PAINT BRUSH HILLS PUMP HOUSE
 GRADING PLAN AND EROSION CONTROL PLAN
 prepared for
PAINT BRUSH HILLS METROPOLITAN DISTRICT

Markup Summary

PAINT BRUSH HILLS PUMP HOUSE
GRADING PLAN AND EROSION CONTROL PLAN
prepared for
PAINT BRUSH HILLS METROPOLITAN DISTRICT

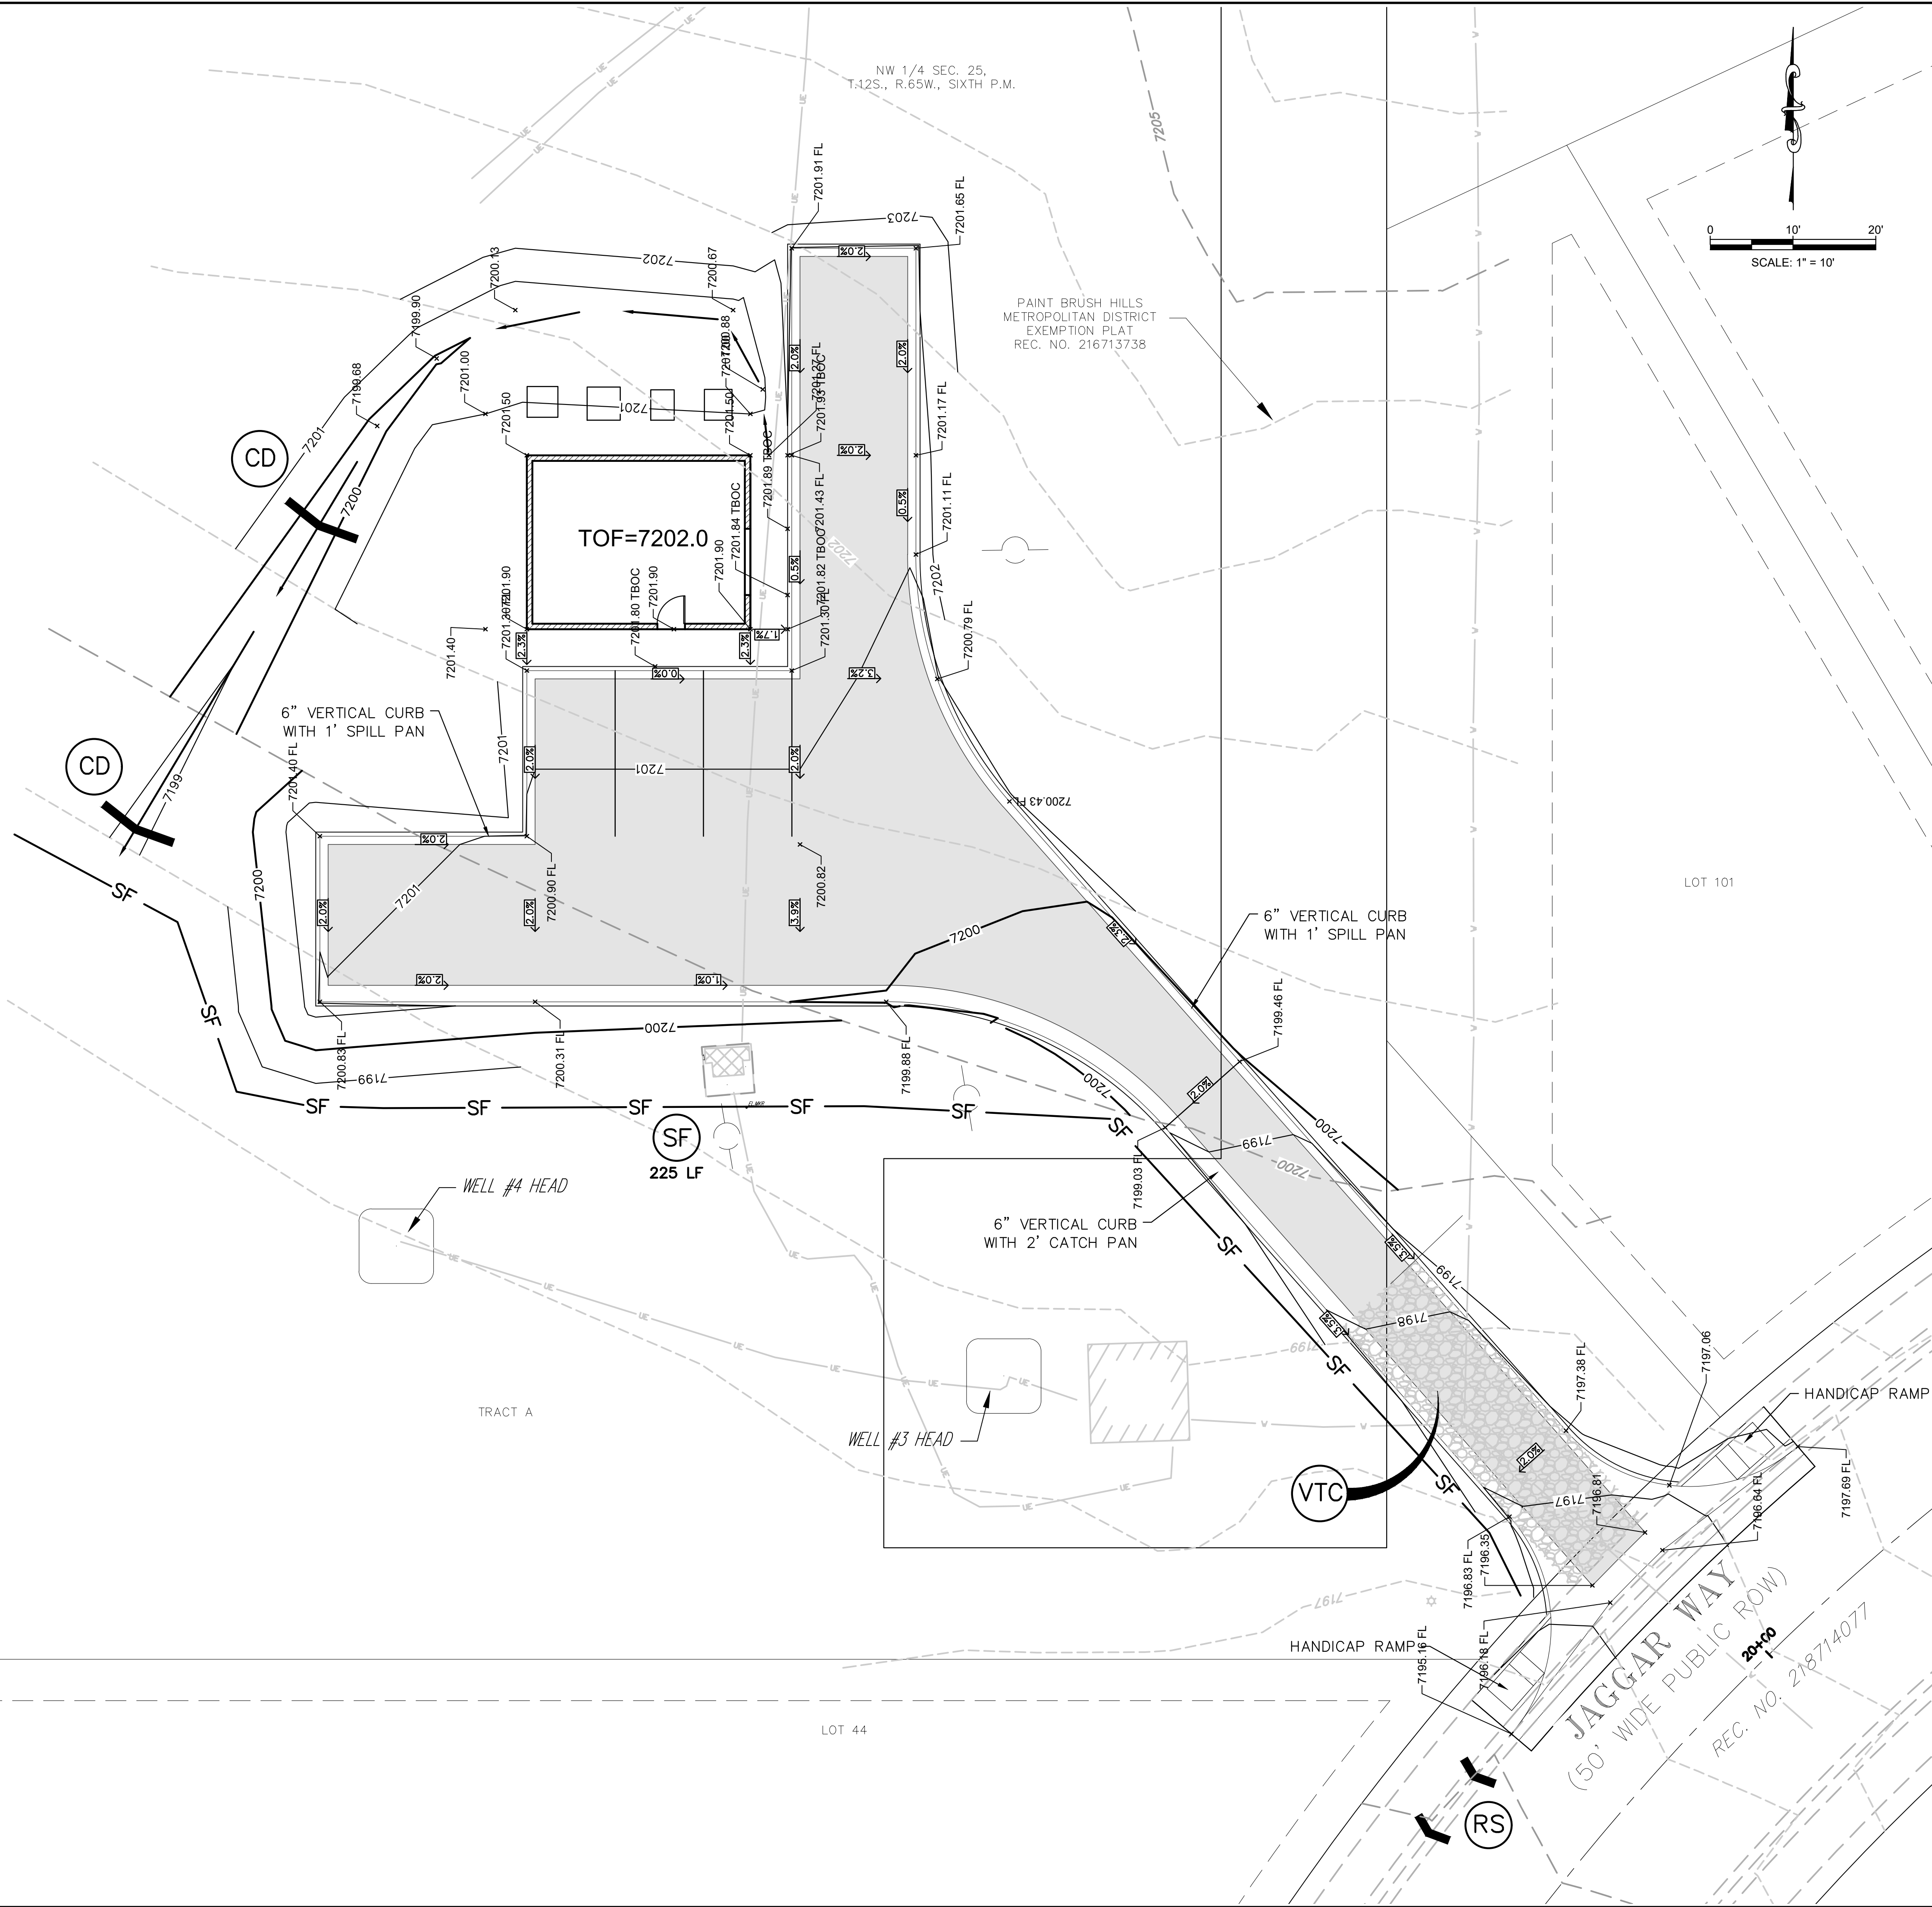
Since the project project is disturbing less than 1 ac. a grading plan is the only requirement.

Remove "and Erosion Control Plan"

Remove the temporary BMPs (VTC, CD & SF) from the grading plan. This is a grading plan only.
